## **Objection to the Amended SSD 7056 - November 2016**

Whilst aspects of the amended proposal as detailed in Response to Submissions Report October 2016 Amended Proposal and Revision C of Plans EA-A are welcome, including the removal of the previously proposed 4 storey “glass box” structure to be constructed between Campbell’s Stores and the Park Hyatt Hotel addresses heritage impact / urban design, the applicant, in two ‘Response to Submissions’ reports dated May 2016 and October 2016 has failed to respond to the amenity impacts.

**Peter & Viki Hutchison**  
**Apartment #4**  
**10 November 2016**

02 EAST ELEVATION
SCALE: 1:200

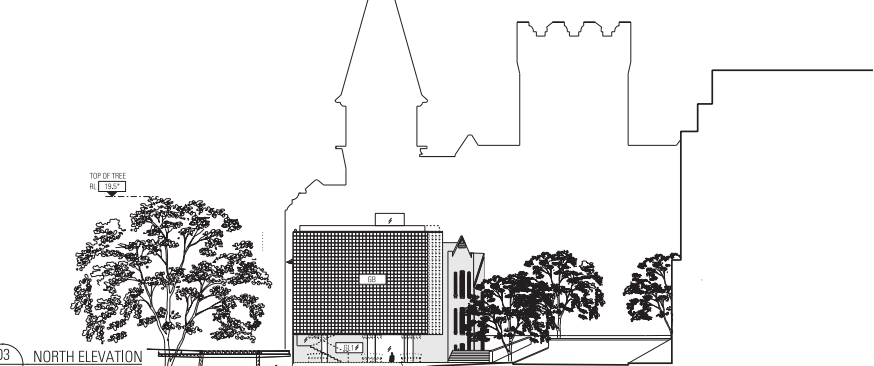
In fact, the proposed passive ventilation design will require Campbell’s Stores’ windows and doors opening onto Hickson Road to be open for much of the year. The “open window” ventilation design will fail to contain noise within the premises and will result in significant noise impact on the residents of 8 Hickson Road and the guests of the Park Hyatt.

The noise disturbance from noise generated from within the premises will be particularly significant as a consequence of the 'open window' ventilation design that will fail to contain noise within the premises.

2. That windows or doors opening onto Hickson Road be kept closed at all times and windows be fixed in a closed position. In respect to openings required for access to Hickson Road, air lock style automatic opening and closing doors need to be fitted and designed, installed and operated so that one of each pair of doors will always be in the closed position at any given time.

**Figure 5** | The approved (left) and proposed (right) Bay 11 roof layout (Source: JPW Architects).

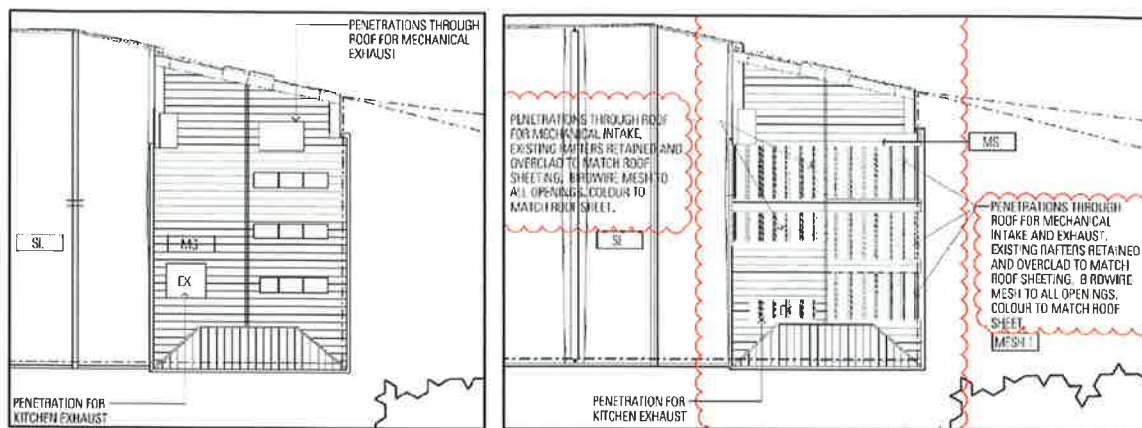
While a detailed design has not been submitted the Roof Plan, EA-A-1005 Revision C and Level 04 Plan, EA-A-1005 Revision C, indicate 18-20 kitchen exhaust fans discharging through the roof of Bay 11. The proposal envisages converting the entire roof space of Bay 11 into a huge exhaust system, all located within approximately 25 metres of 8 Hickson Road and the Park Hyatt.

The proposal to relocate all the mechanical exhaust system for kitchens and other areas from the southern end of the building to the roof of Bay 11 will result in substantial impact on our amenity due to noise,

Even though the applicant has not submitted a detailed design for the mechanical exhaust system both the mechanical ventilation report and noise impact report state that in order to reduce smoke, smell and noise impacts of the system a riser of unspecified height and noise baffles, of unspecified design, will be required on the roof of Bay 11 in an attempt to mitigate the amenity impacts of the exhaust system.

The proposed risers and noise baffles for the mechanical exhaust system on the roof of Bay 11 will substantially and negatively impact on our views of the Sydney Opera House and Sydney Harbour from the living room and bedroom of our apartment on level 4 across the road at 8 Hickson Rd.

1. That all of the mechanical exhaust system including machinery, flues, vents and baffles be located at the southern end of Campbell's Stores so as to minimise noise, fumes, vibration and smell impacts on the residents of 8 Hickson Road and guests at the Park Hyatt Hotel.

3. That there be no penetrations, structure or any plant, including flues, vents, plant or equipment located through or on the roof of Bays 9,10 and 11
